Inner West Council Response: SSD-78268465 – Newington College Redevelopment (Concept and Stage 1)

Property: 200-244 Stanmore Road and 221-235 Stanmore Road, Stanmore

Attachment A - Consolidated Inner West Council Officer comments SSD-78268465 – Newington College Redevelopment (Concept and Stage 1)

The third floor of Concordia is expected to accommodate staff space and GLAs, the top floor is anticipated to be required for roof-top plant and the lift overrun.

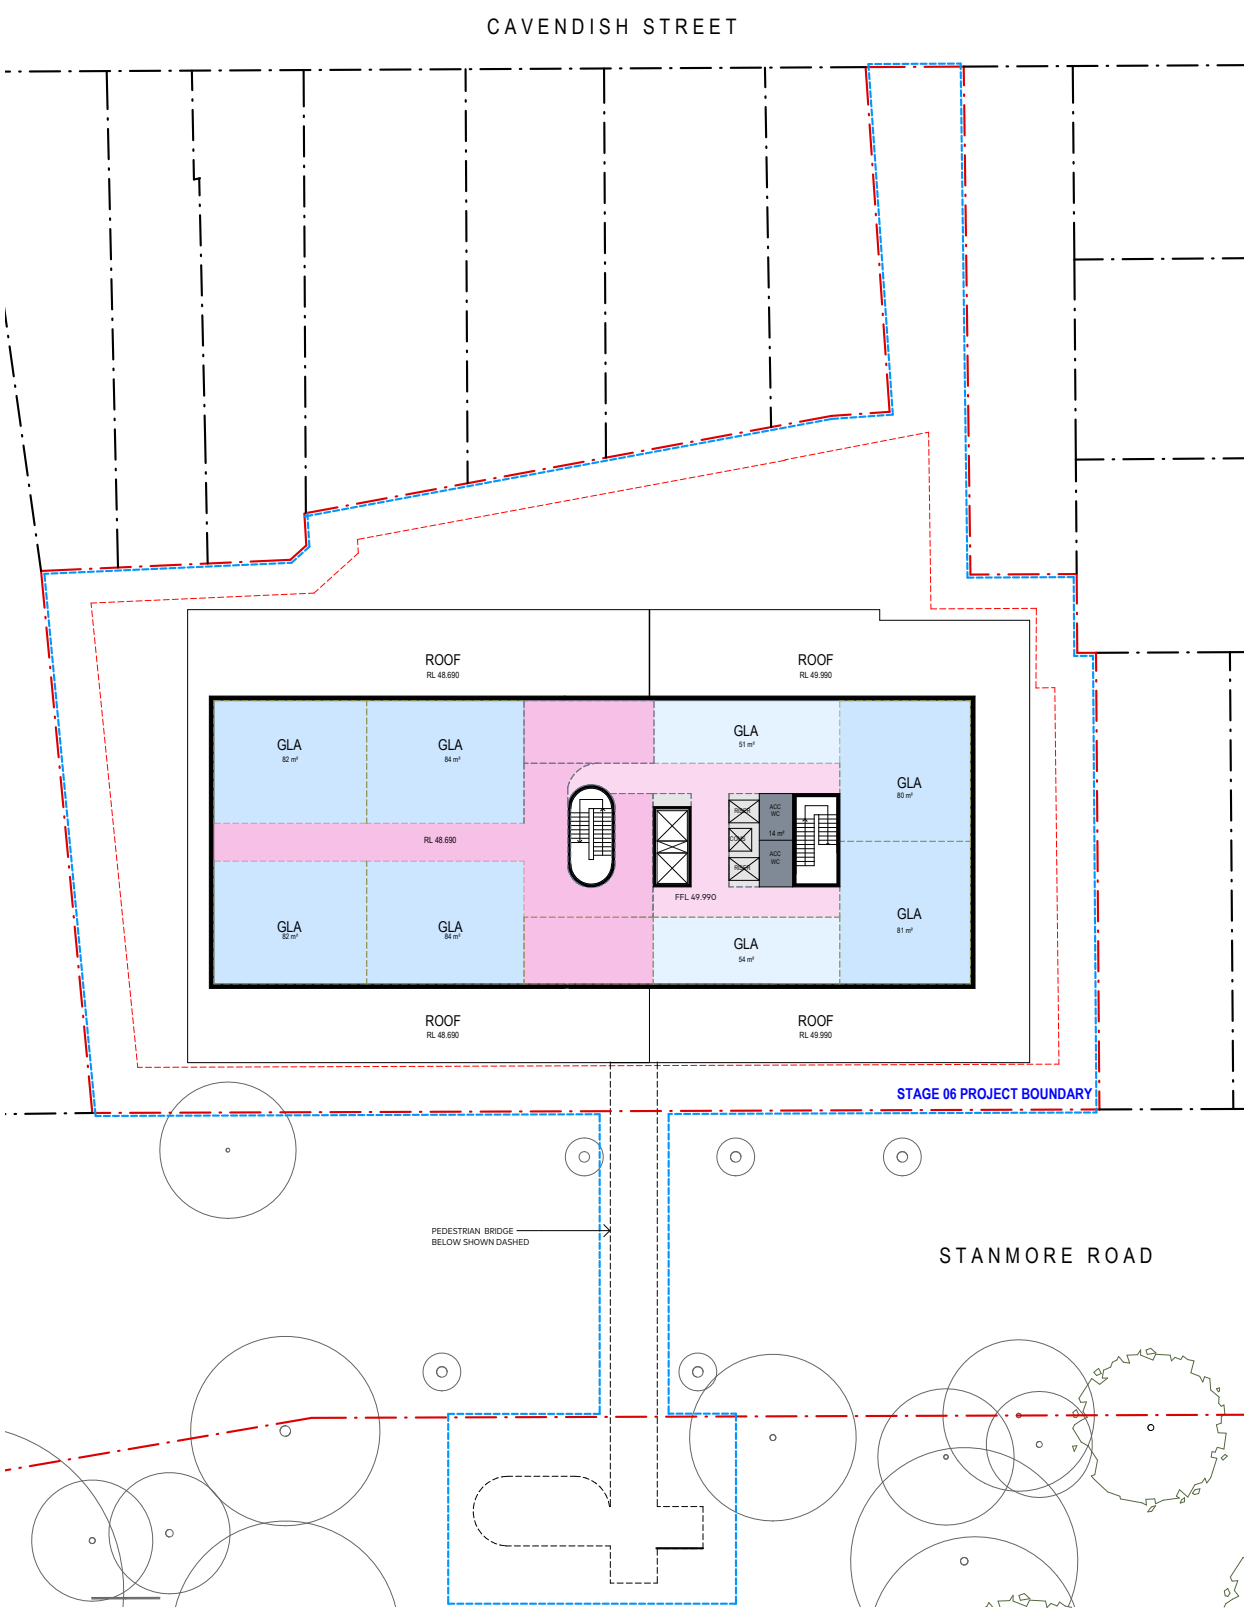
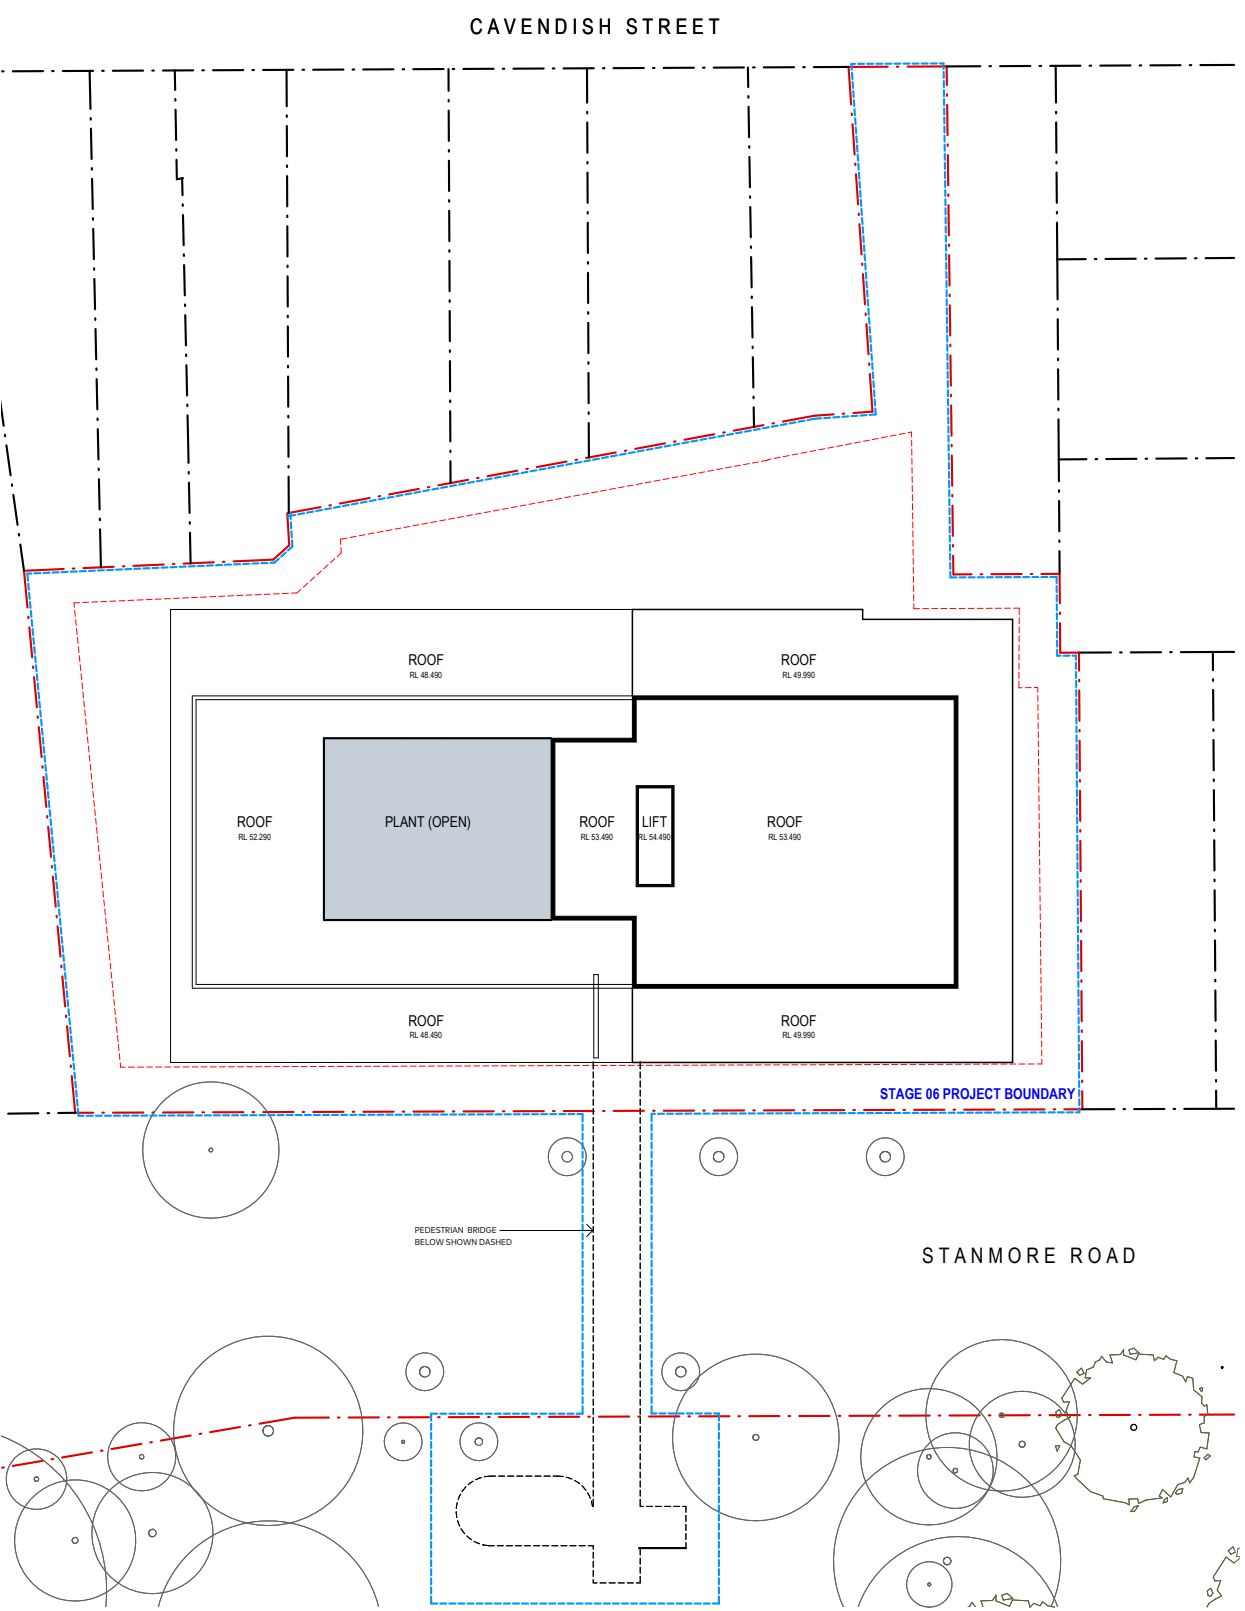
Further detail and refinement are required to demonstrate that the proposed building envelope and massing of the Concordia building presents as an appropriate design response to the site and its context, including the following:

- f) Further refinement of the proposed scale and massing, having regard to the prevailing two storey character of development along the street and amenity impacts. Particular consideration should also be given to the building edges and interfaces with neighbouring residential land to ensure an appropriate built form transition.
